Recommendation Report for Works to Tree(s) on trees subject to a Tree Preservation Order (TPO)

REF NO: AW/342/20/T

LOCATION: 8 Arun Way
Aldwick Bay Estate
PO21 4HF

PROPOSAL: Removal of dead wood from 3 No Silver Birch (T1,T2 and T4)
Removal of dead wood from 1No. Oak (T3)
Removal of dead wood from 2No Lombardy Poplars (T6 and T7)
Crown reduction of 4 No Purple Beech (T5) to height of 17m and spread of 8m, a spread of 8m Crown reduction of 2 No Persian Ironwood (T8) to height and spread of 4m , (T11) to a height and spread of 4m and a crown lift to T9, T10, T12 on north aspects only to provide maximum 5 metres overhead clearance above carriageway.

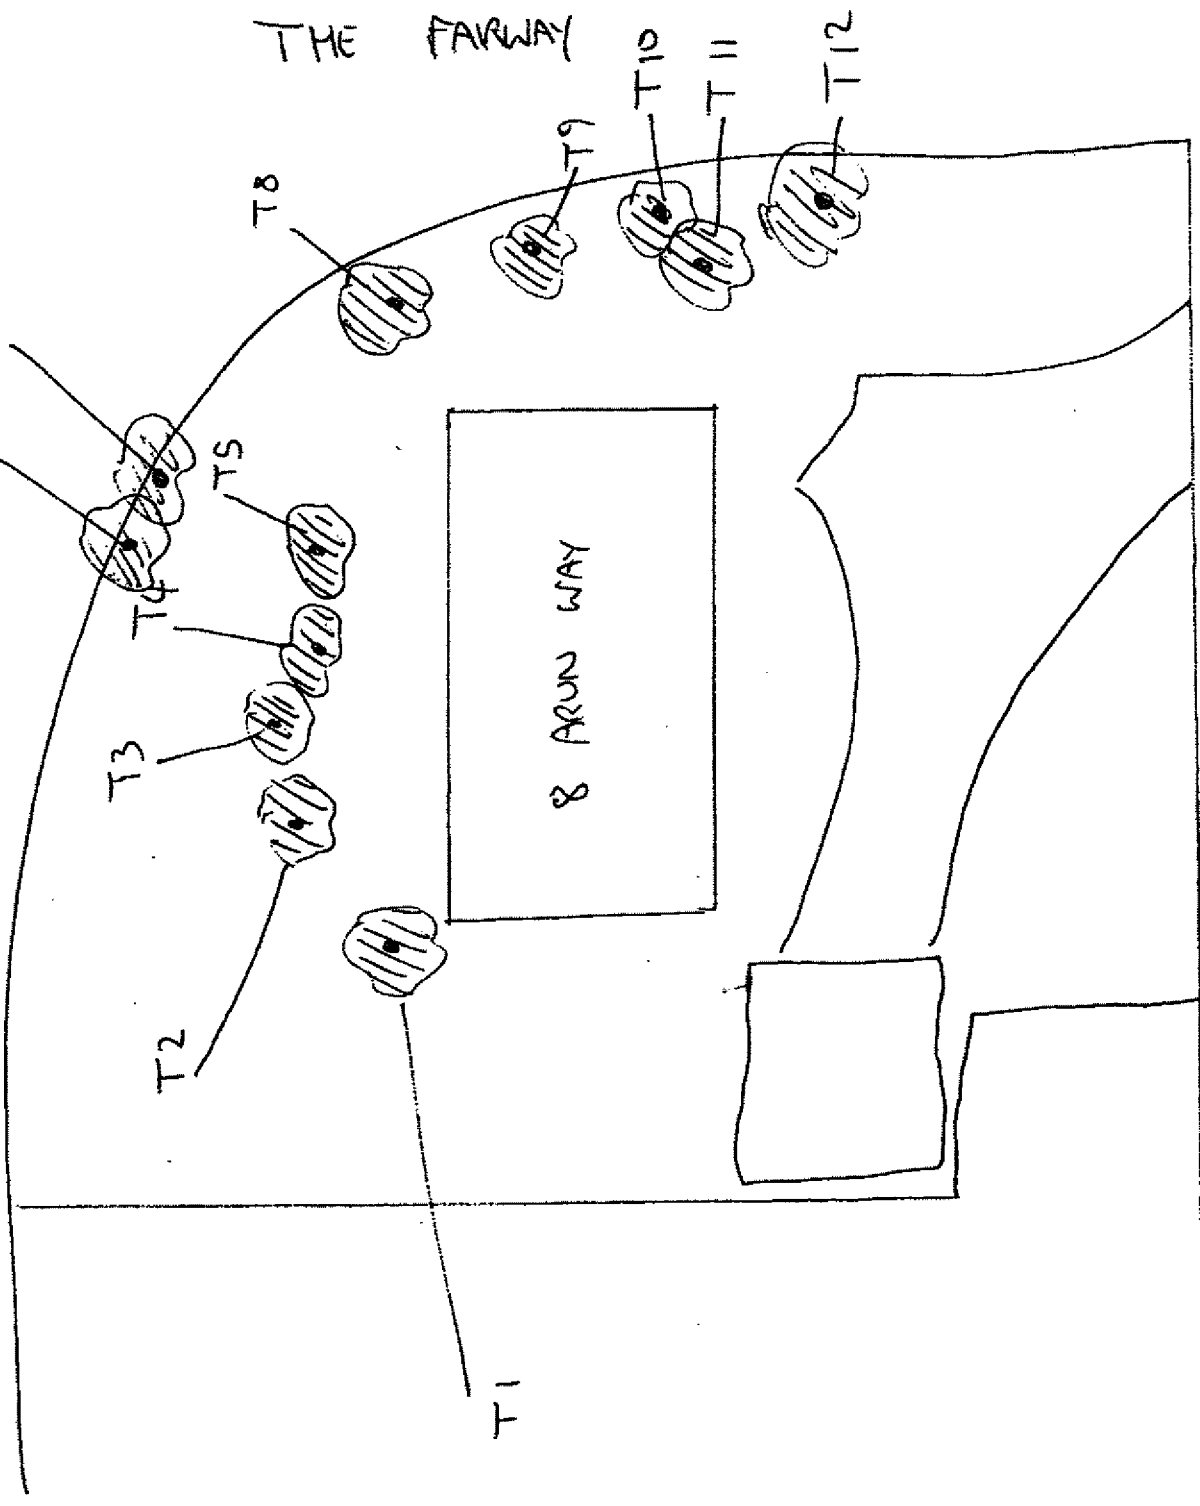
- T5 is discreetly located within the garden interior. Outwardly and from distance (roadside) it appears to be in a fine physiological state with evidence of past reduction of selected branches, presumably to restrict its influence over adjacent dwelling and garden.

- T8 & T11 are undoubtedly of visual interest and have characteristically erratic form, exacerbated by their situation beneath dominant beech (T9, T10, T12). Outwardly and from distance (roadside) they appear to be in a fine physiological state.

- T9, T10, T12 grow prominent and equidistant along the north boundary and are collectively a significant feature with landscape value. Their unmodified upper crowns and apparent good health (restricted view of stem base/ground) qualify them as trees of high amenity value.

· Notable exception is that proposed for T9, T10, T12. Collectively and individually these trees are a significant feature in the local landscape and assumed to be in adequately sound and healthy condition.

The tree surgery proposed in the

application would result in excessive reduction of their landscape impact and undue detriment to the visual amenities of the locality.

- T9, T10, T12 Replace crown reduction proposal with crown lift on north aspects only to provide maximum 5metres overhead clearance above carriageway.

The agent on the application has confirmed they agree to the recommended reduced scheme.
